PLANNING AMENDMENT

Application No. **H16/0127/76**
 Date Registered **02 MAY 1996**
 Case Officer **DR**

Re: Wygate Park, Spalding - Phase 8 & Amendments to Phase 7
Planning application ref: no. H16/0127/96

Amendment: Revised layout (and as per letter) Drawing No: 233/55/3

Dwg 233/55/3. Scale 1:500. Apr. 96

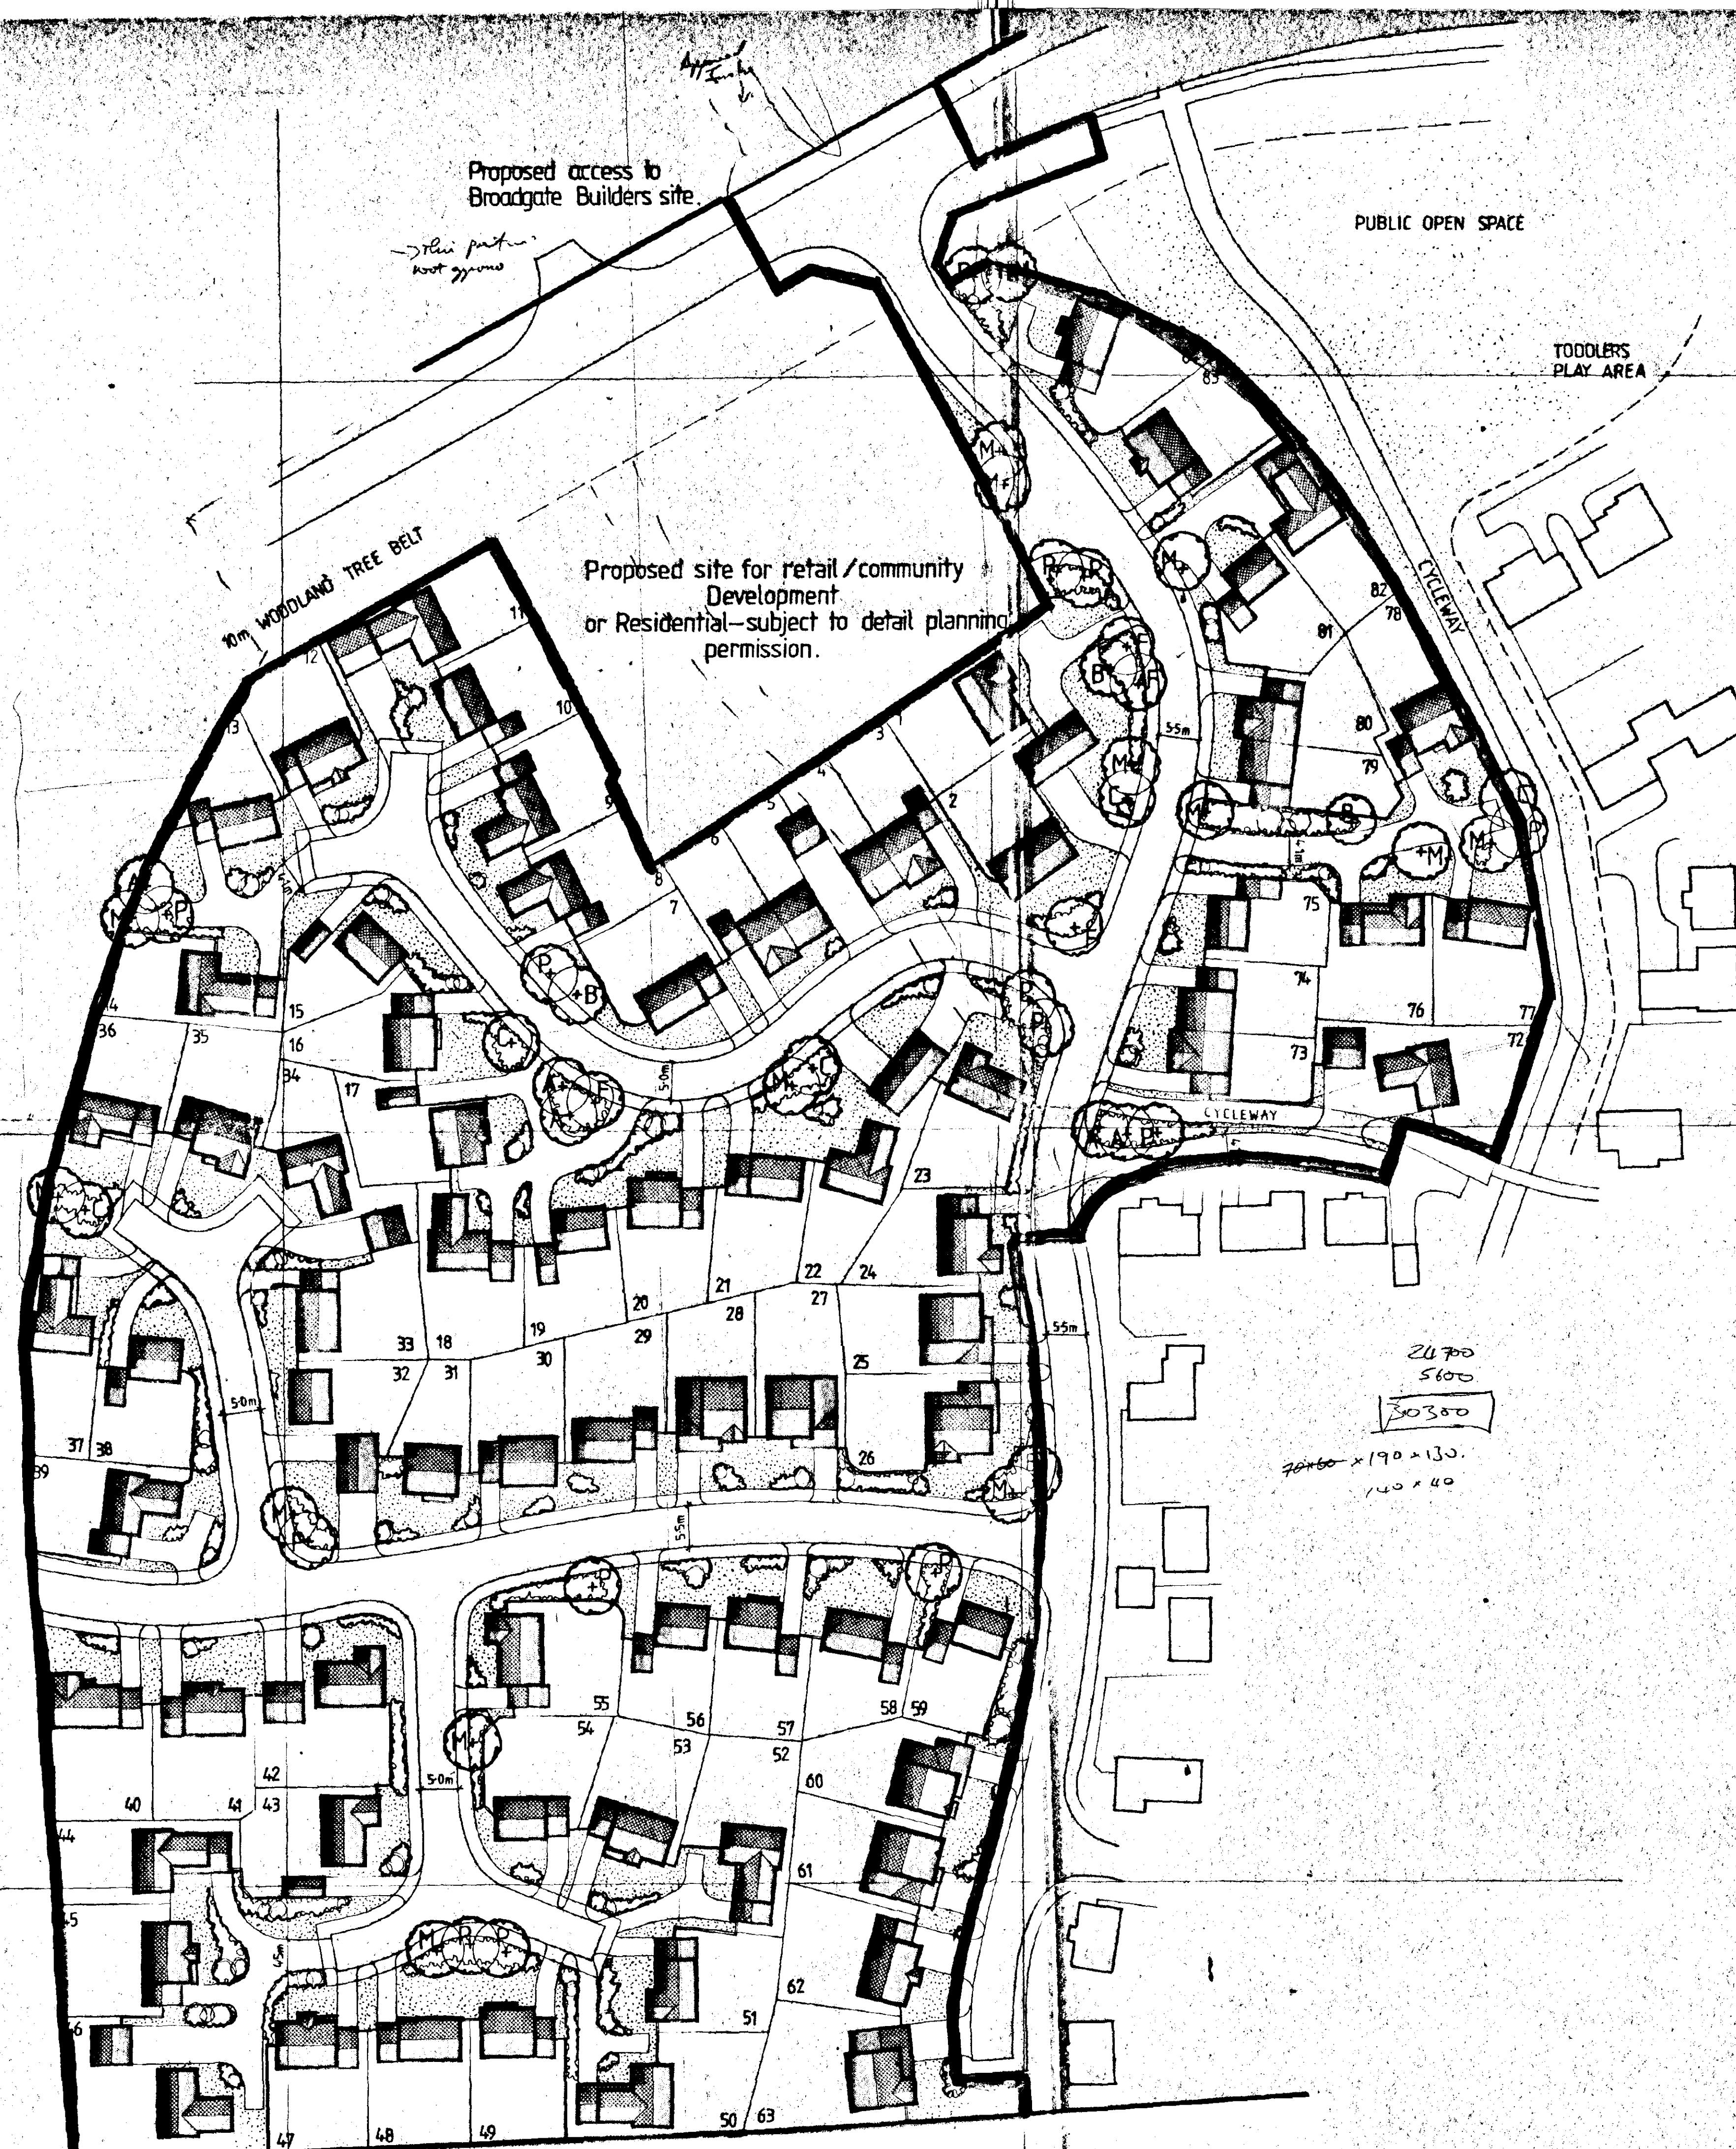
Revised Layout
(and as per letter)

- 1) Detailed amendments now incorporated in enclosed drawings.
- 2) Revised layout drawings enclosed.
- 3) I would reiterate my comments to you, that we will construct the distributor road on land that we own. We have made provision for an access into Broadgates land as indicated on the enclosed drawings. I would also point out that we are able to implement an approval to the enclosed proposal, whereas Broadgates will be unable to implement their permission as submitted. We therefore wish our application to be determined as indicated on the enclosed drawings, (Drawing no. 233/55/3) and request these be substituted for those enclosed with our original application.
